From: Ian Hayward <[REDACTED]>
Sent: 08 January 2015 12:29
To: Damian Sullivan
Cc: Oliver McGowan; Peter Evans
Subject: WSCC Strategic Planning Response for Discharge of Conditions - FG/141/14/PL
Attachments: FG14114a.docx

SUBJECT: FG/141/14/PL - Demolition of existing garage & external store, new bin & recycling area, new take away hatch with raised gantry access & single storey rear extension, including extraction system.

The Bluebird Cafe, South Drive, Ferring, BN12 5QU

Drawing
Site Setup Plan

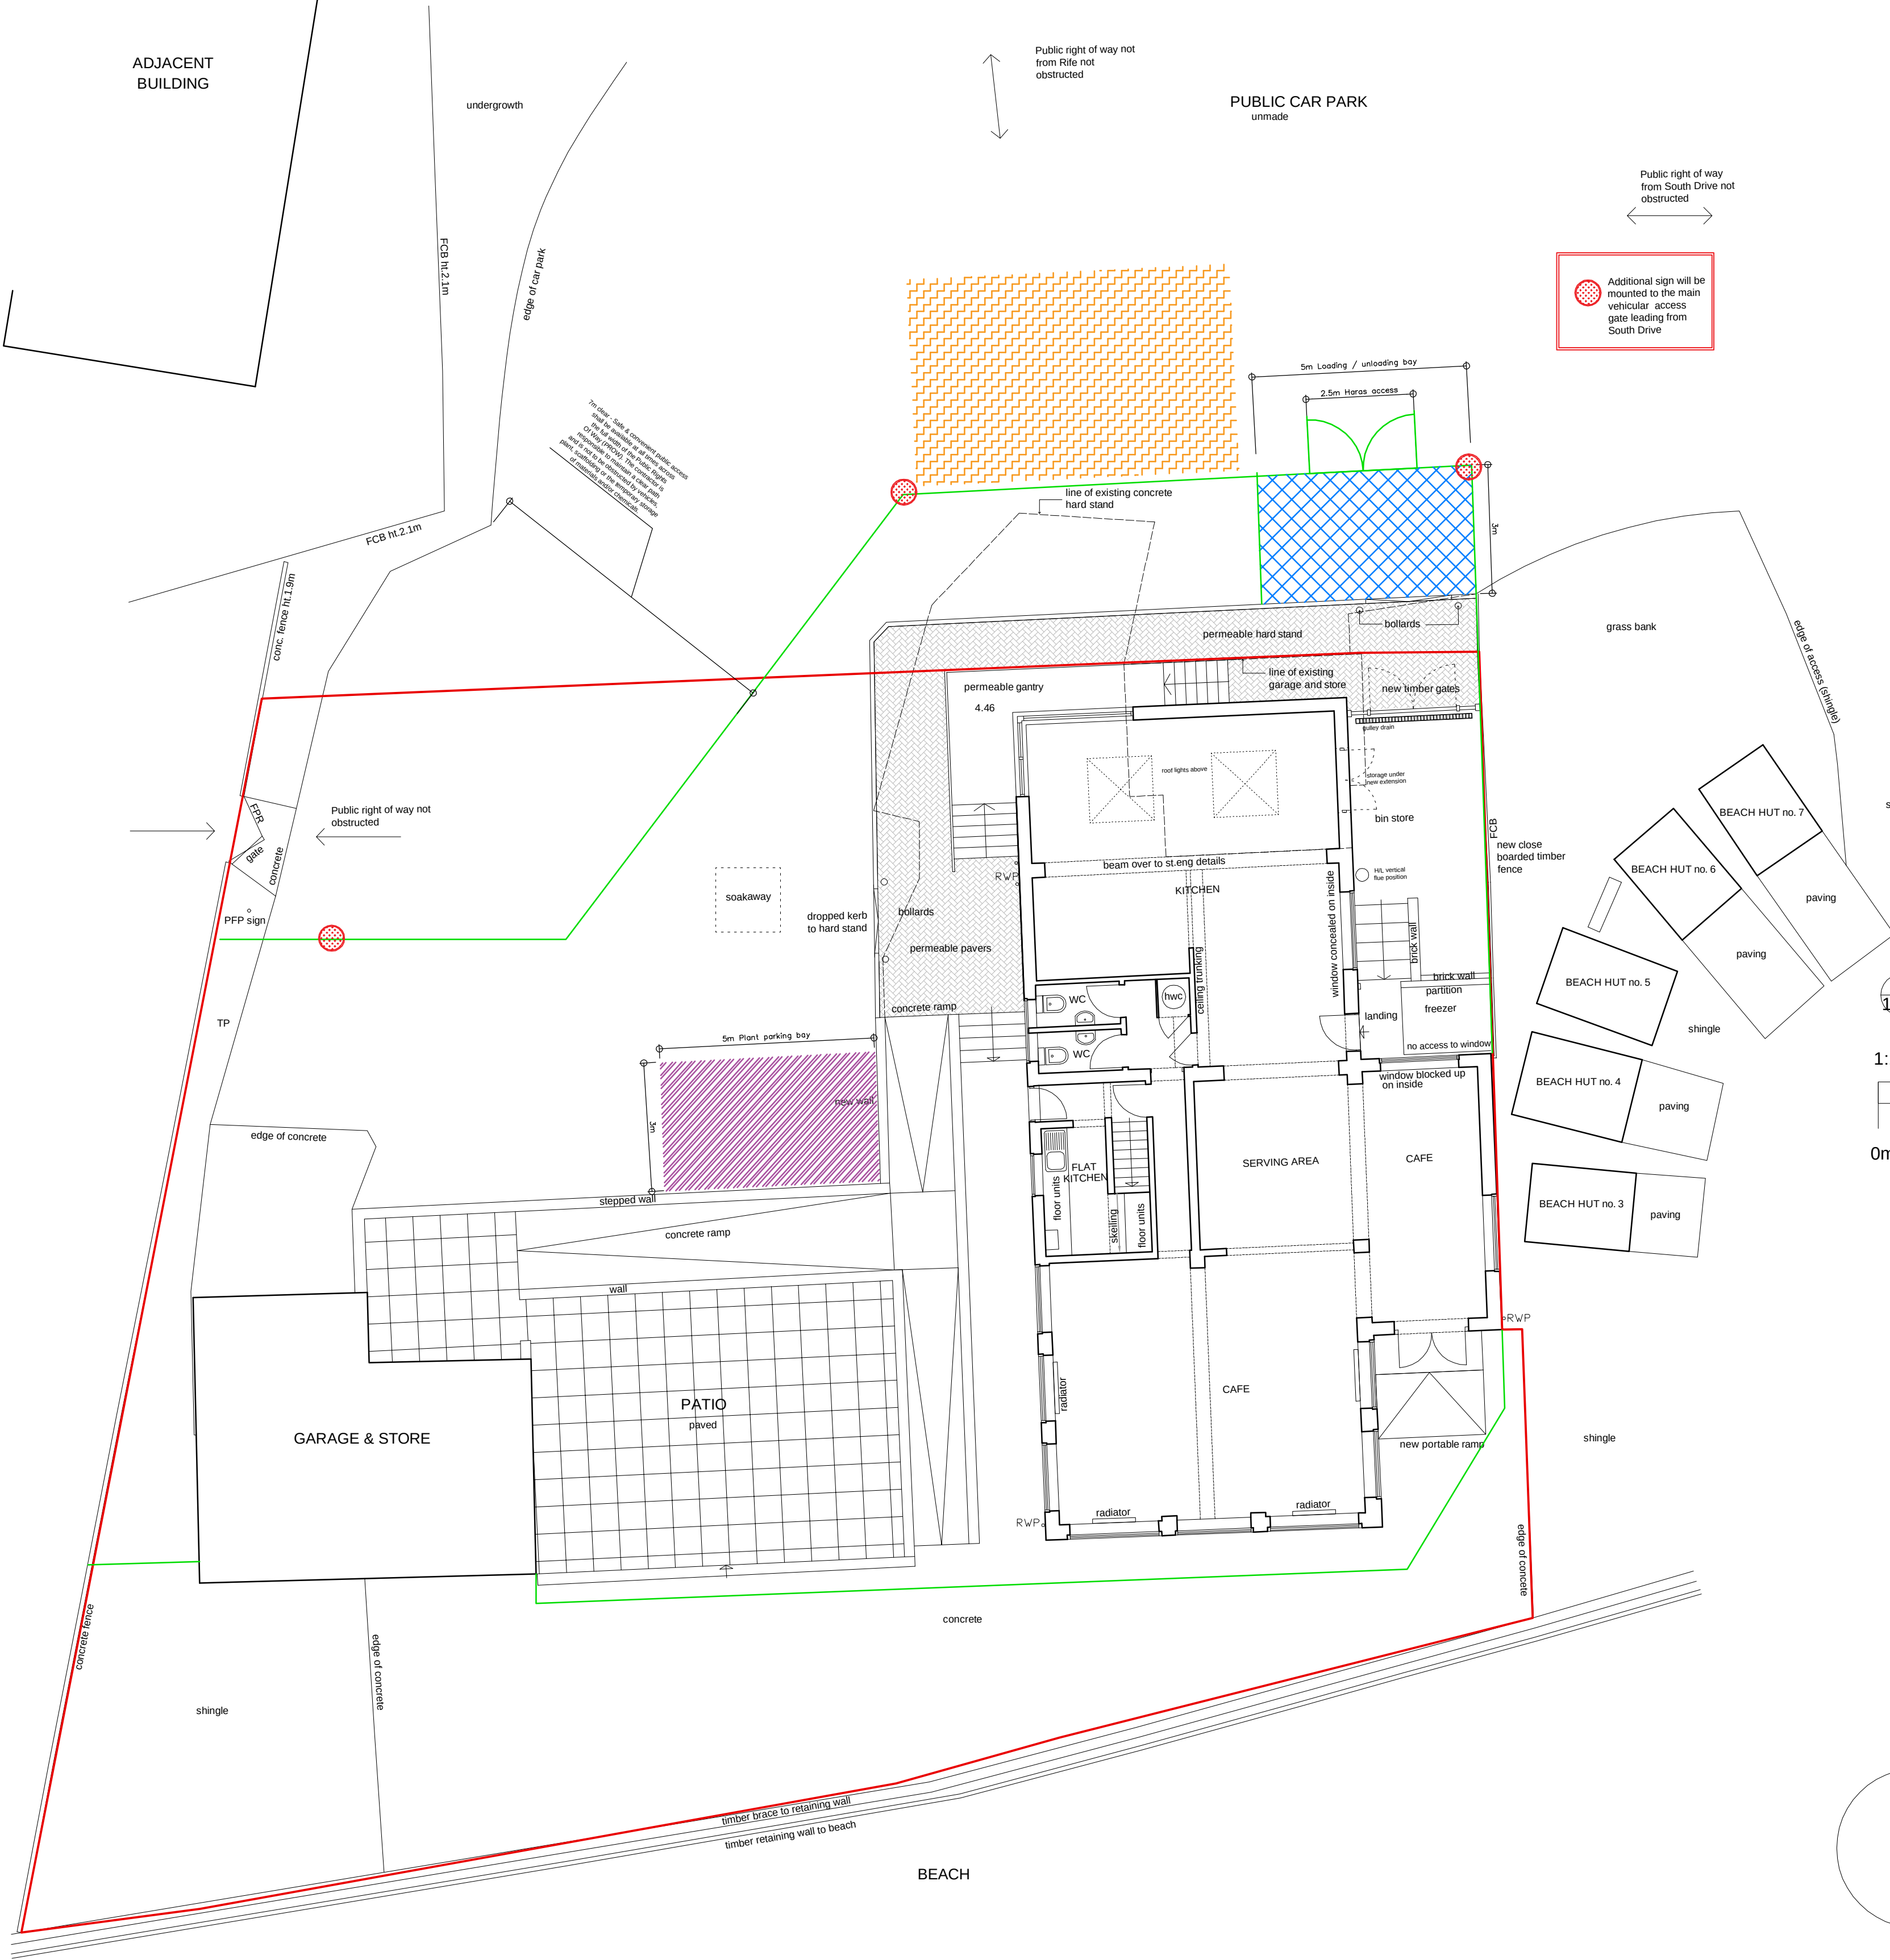
I have consulted with WSCC PROW, please find attached the Strategic Planning response in regard to the Discharge of conditions for planning consent FG/141/14/PL. These comments are based upon Plan BBA -1050-Revision B. In summary the plans and details provided are considered to be appropriate.

No development shall commence until such time as plans and details have been submitted to and approved in writing by the Local Planning Authority showing the site set up during construction. This shall include details for all temporary contractor buildings, plant and stacks of materials, provision for the temporary parking of contractors vehicles and the loading and unloading of vehicles associated with the implementation of this development. Such provision once approved and implemented shall be retained throughout the period of construction.
